CONSULTEE RESPONSE (Council's Arboriculturist)

Reference: BE/48/25/PL

Proposal: 7no. residential dwellings and associated works including new access. This application is a Departure from the Development Plan and is in CIL Zone 3 and is CIL Liable as new dwellings.

Location: Rear of Regal House and Wayside, Shripney Road, Bognor Regis, PO22 9NP

- 1 The tree protection plan WTP2
- 2 Data collection – Tree schedule & explanatory notes
- 3 Arboricultural Method Statement

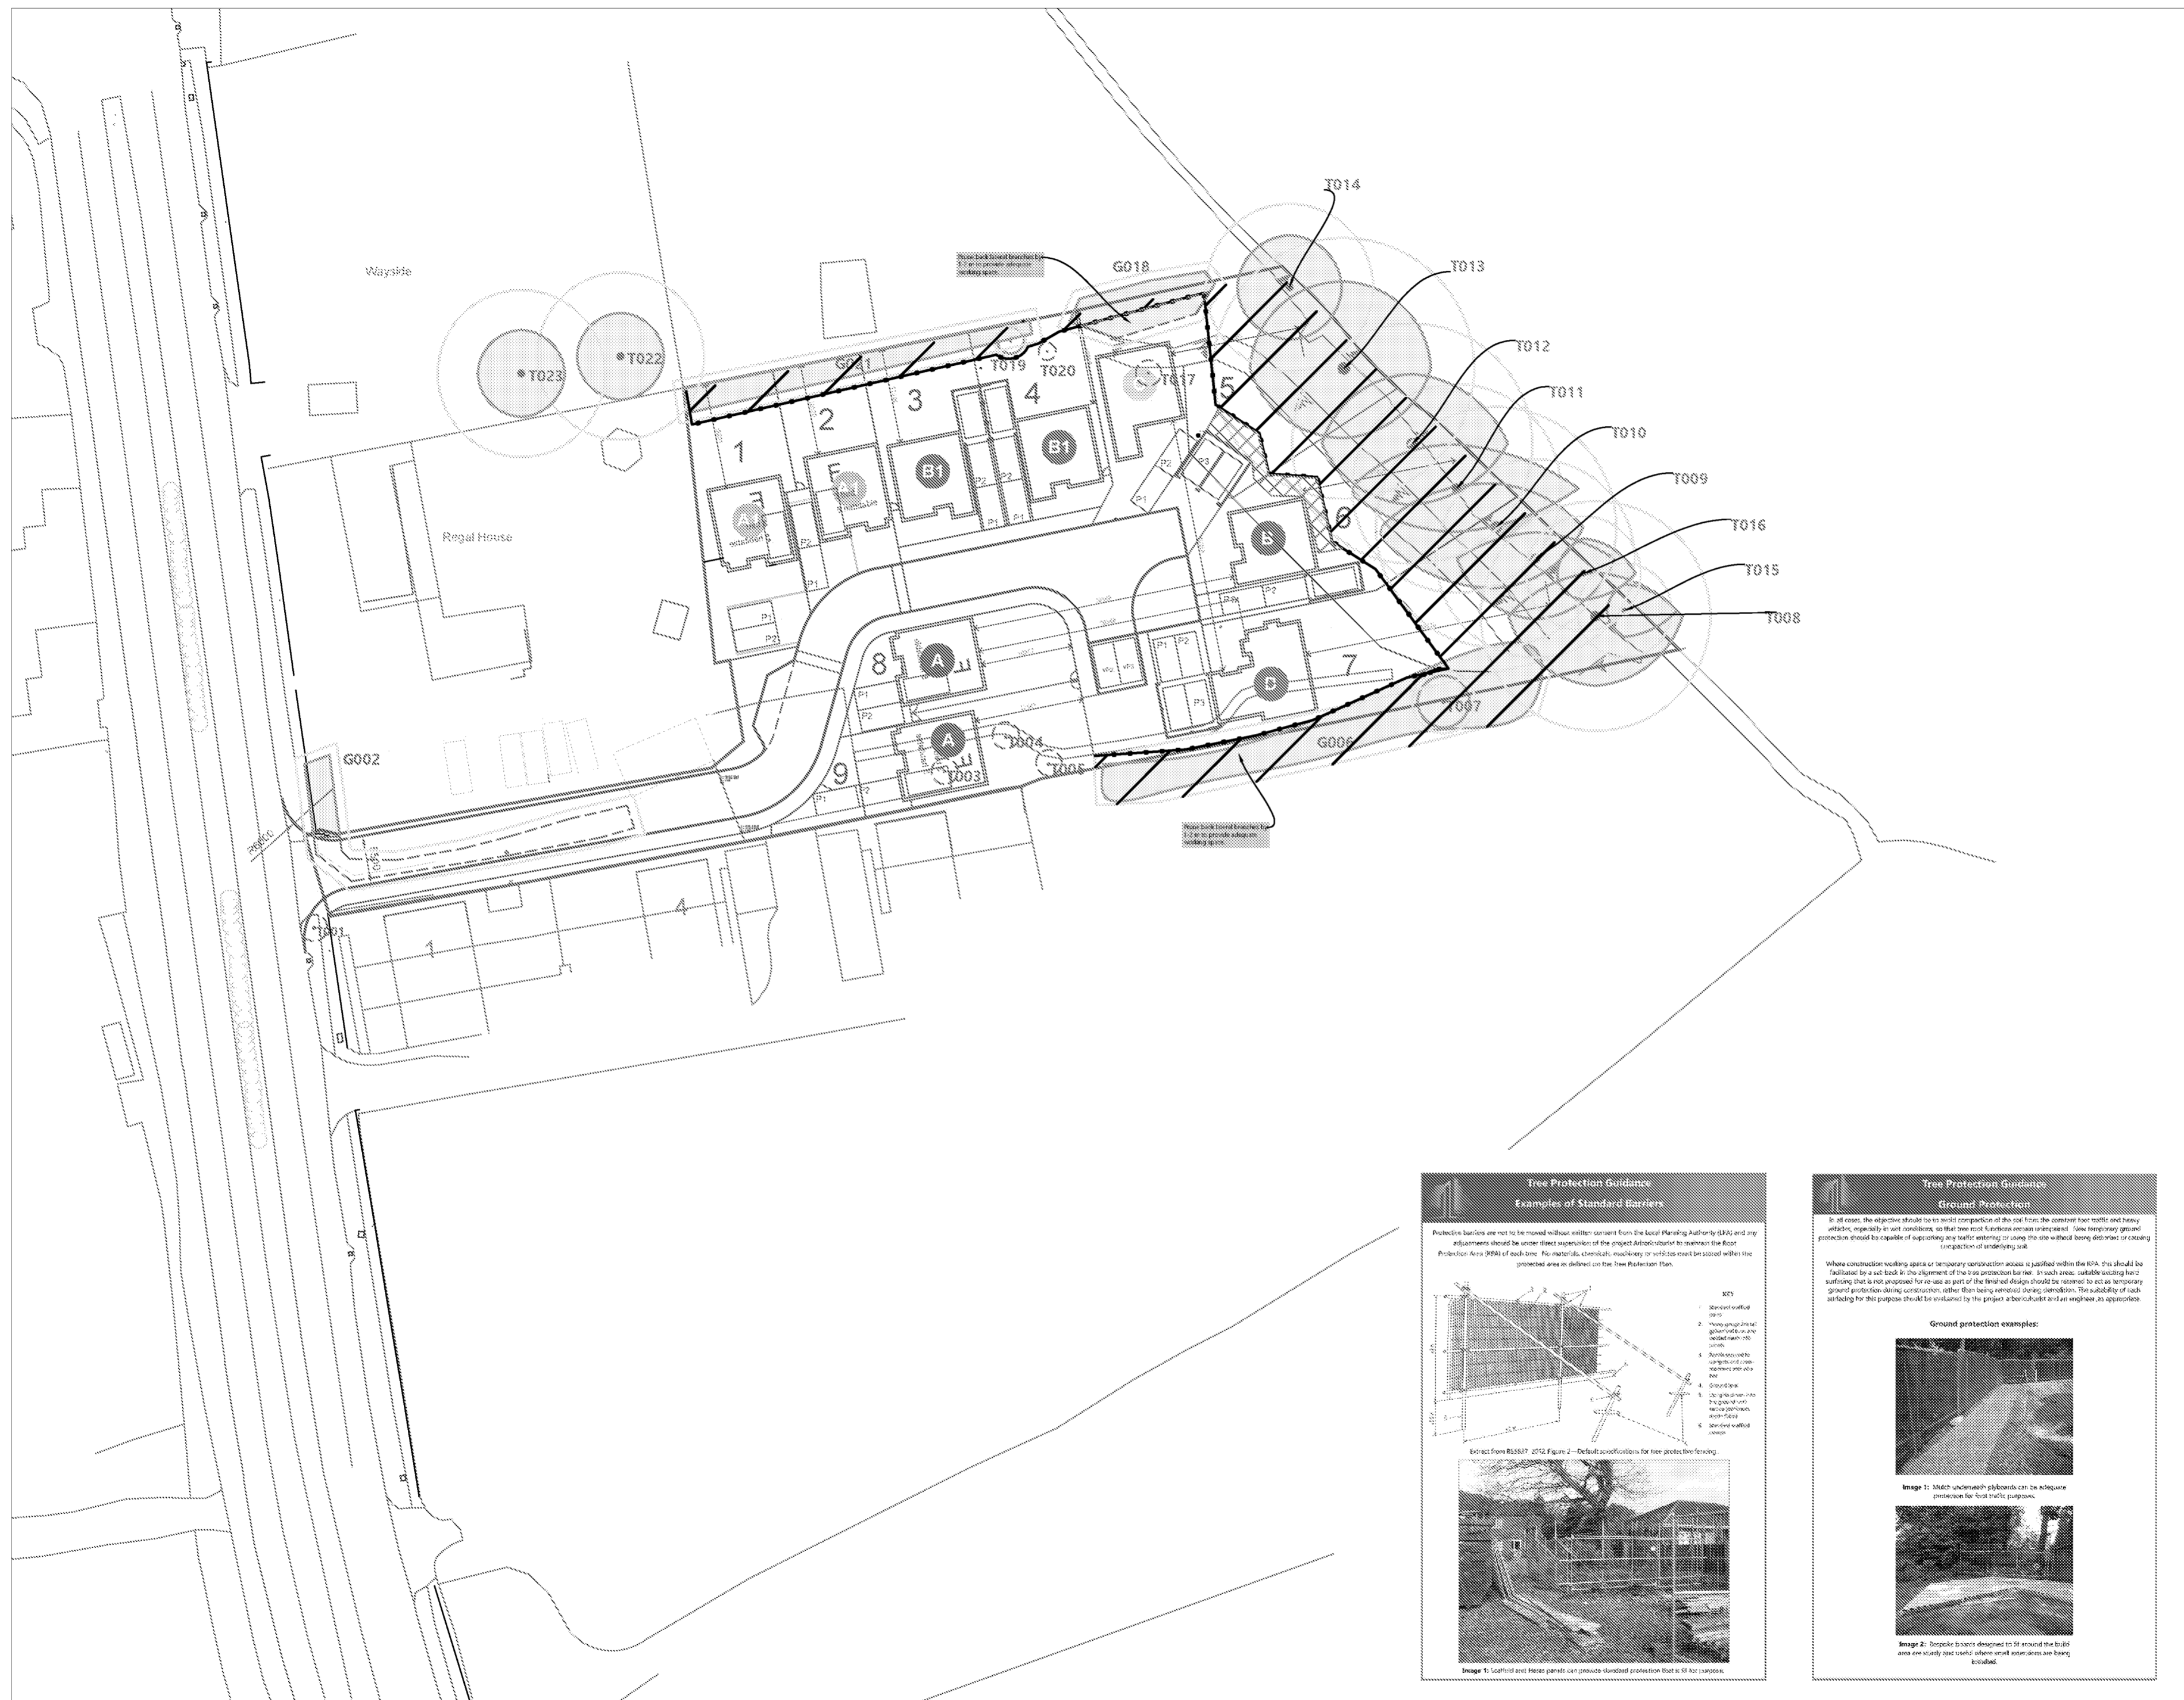
High value trees to the east of the applicant's site are outside of the construction area, with their nominal root protection areas influencing the line of demarcation. Robust protective fencing will need to be installed along this line to form a construction exclusion zone, to the specification described on the TPP (BS5837:2012, Figure 2).

Before any machinery is introduced to the site or construction work takes place, a brief written report (with supporting photographic evidence) is required from the Arboricultural Consultant representing the site owner(s), confirming and demonstrating that all ground protection and protective fencing has been assessed and is 'Fit for Purpose' as required under British Standard 5837:2012, erected and positioned exactly as shown on the **Tree Protection Plan, dwg. WTP3**

-CONSTRAINTS KEY-

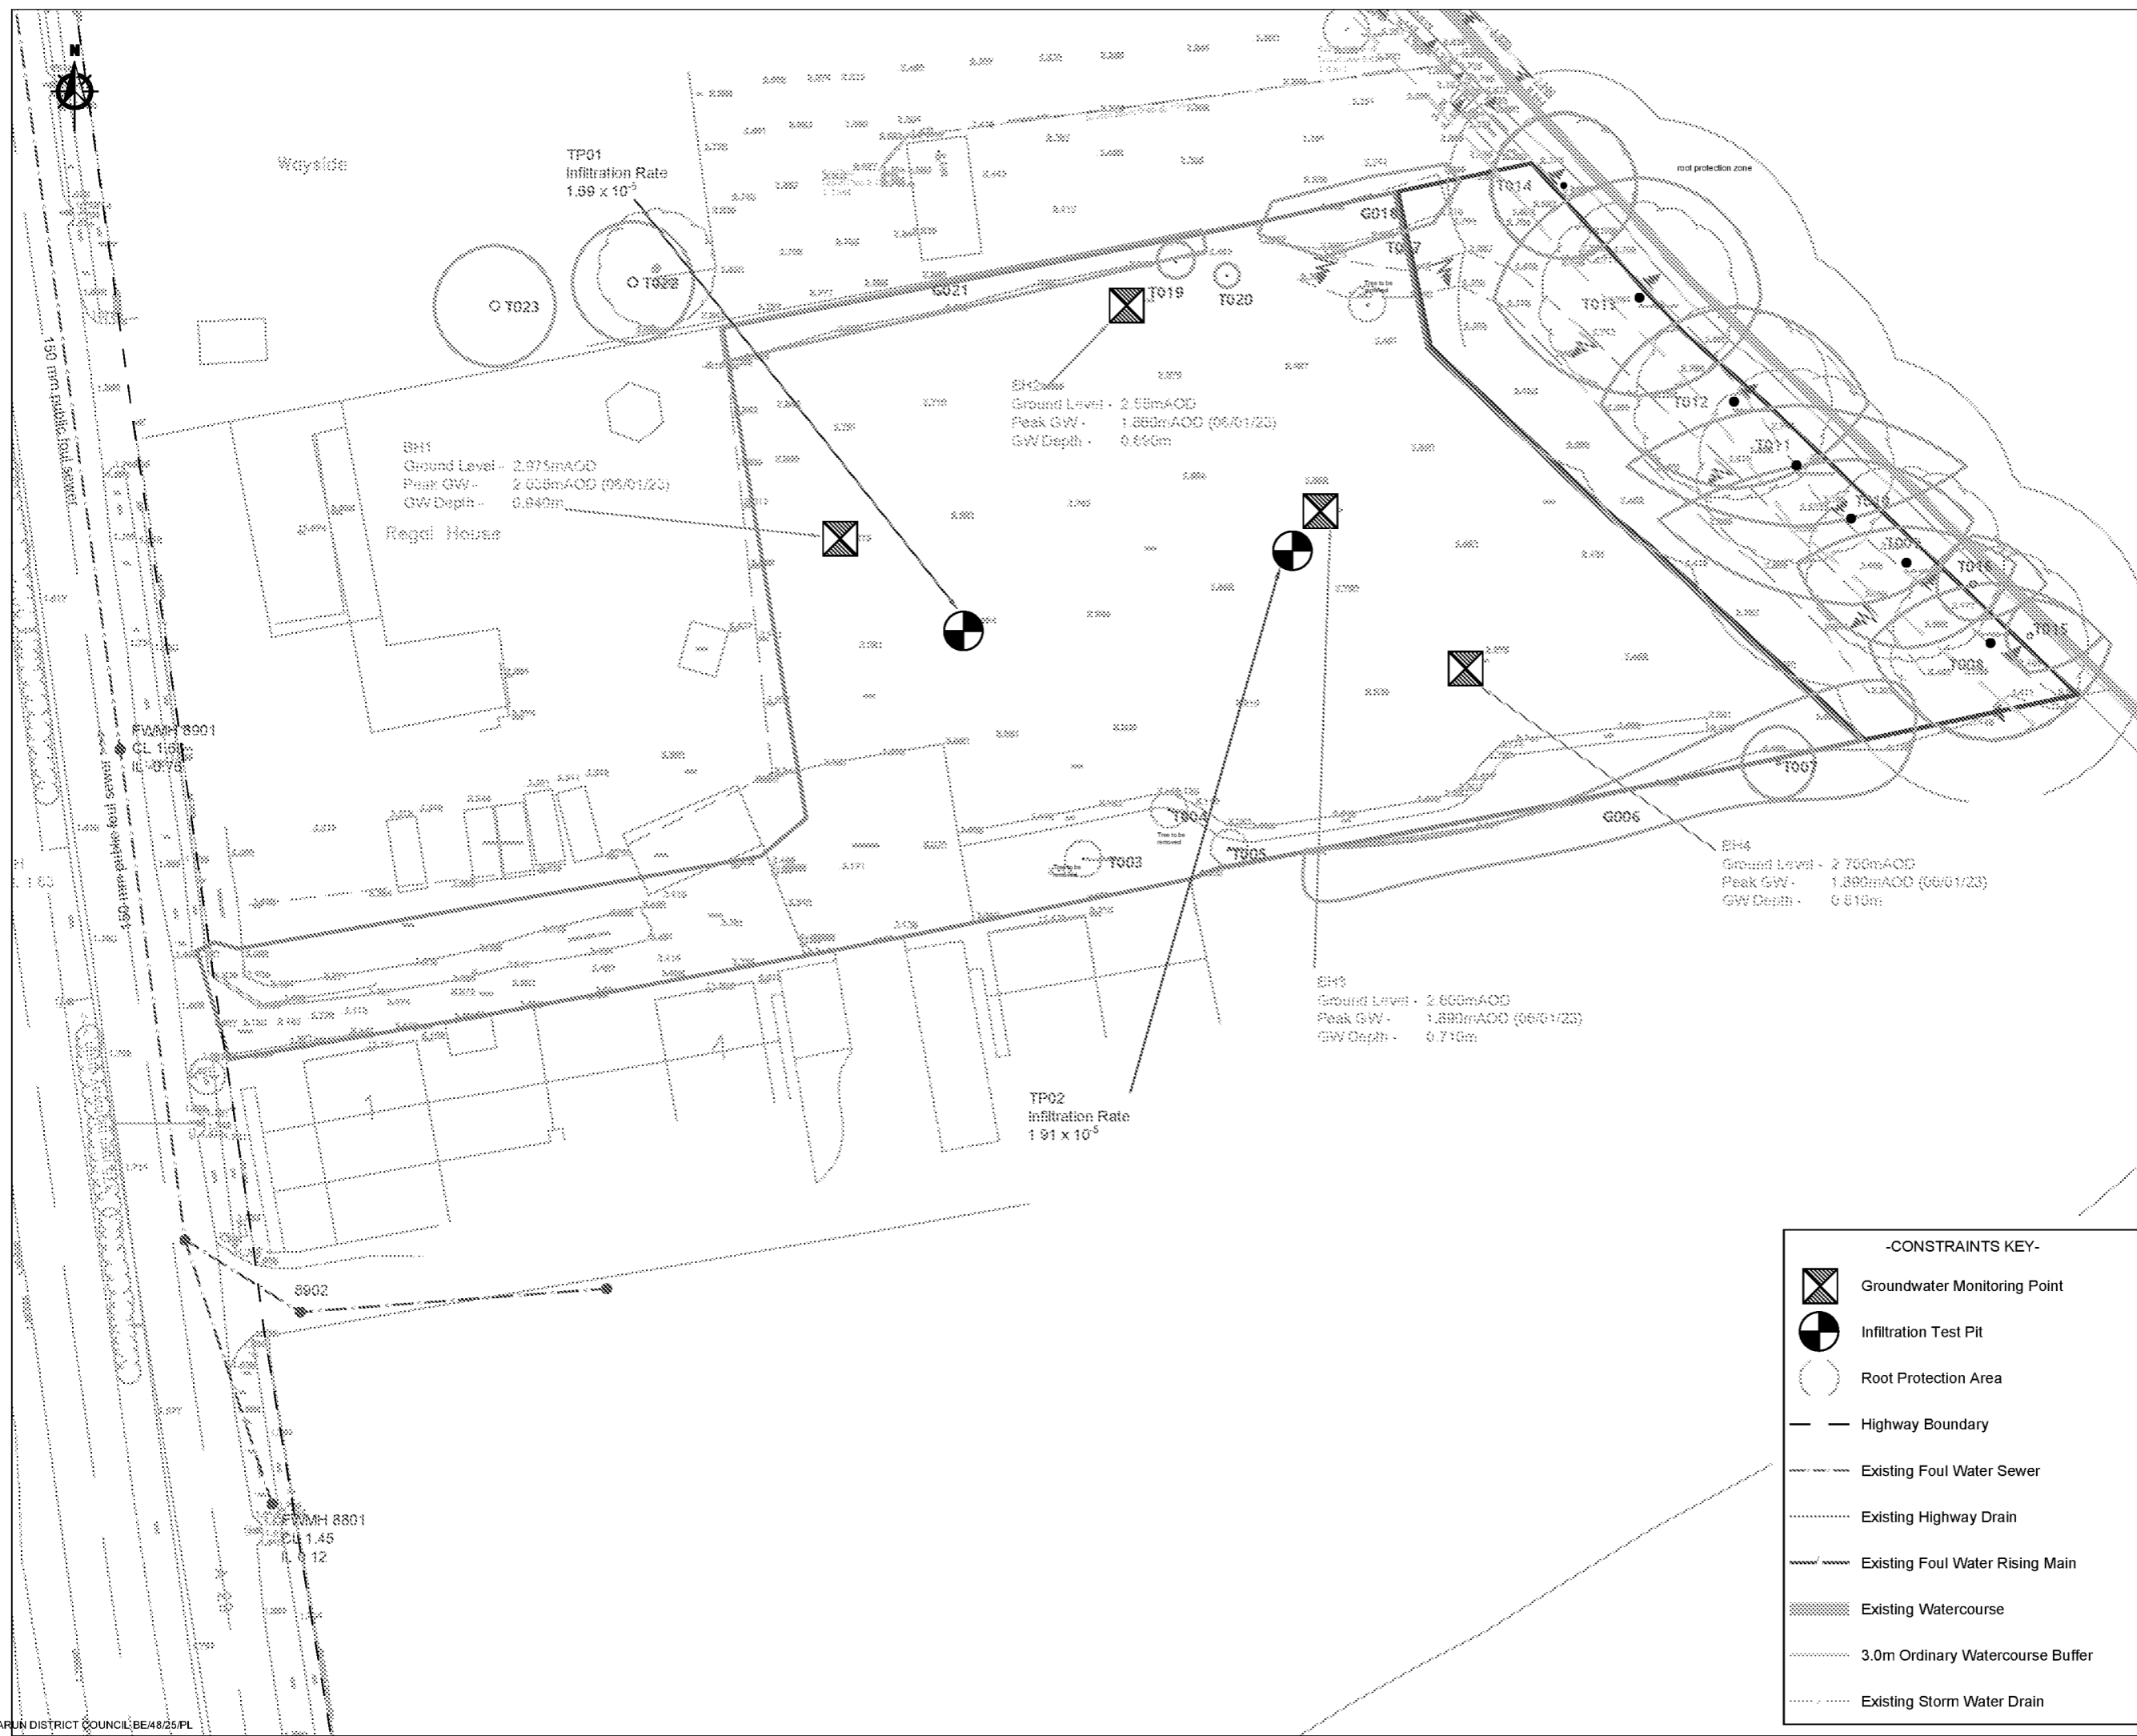
I draw attention to the nominal RPA of retained trees and their growth potential as obvious constraints to the siting of any SUDS feature, soakaway or introduction of subterranean utility apparatus. The provision of appropriate buffer/easement around such features must also take into account tree growth potential (roots) to ensure long-term integrity of apparatus and permit their future maintenance.

The proposed SWD strategy relies on infiltration across the site and incurs no significant arboricultural impact.

If our Drainage Engineer does not support the proposed SWD strategy and favours a discharge to existing watercourse due east of the site, please seek my further comments so that I may advise on potential impacts to high value trees (TPO).

Should a facility for diversion of surface water to the drain east of the site be an essential component of the SWDS, then a route should be found which does not involve higher-value (Category A/B) tree removal or significant damage. Any essential RPA incursion is likely to require a trenchless solution to instal subterranean pipework.
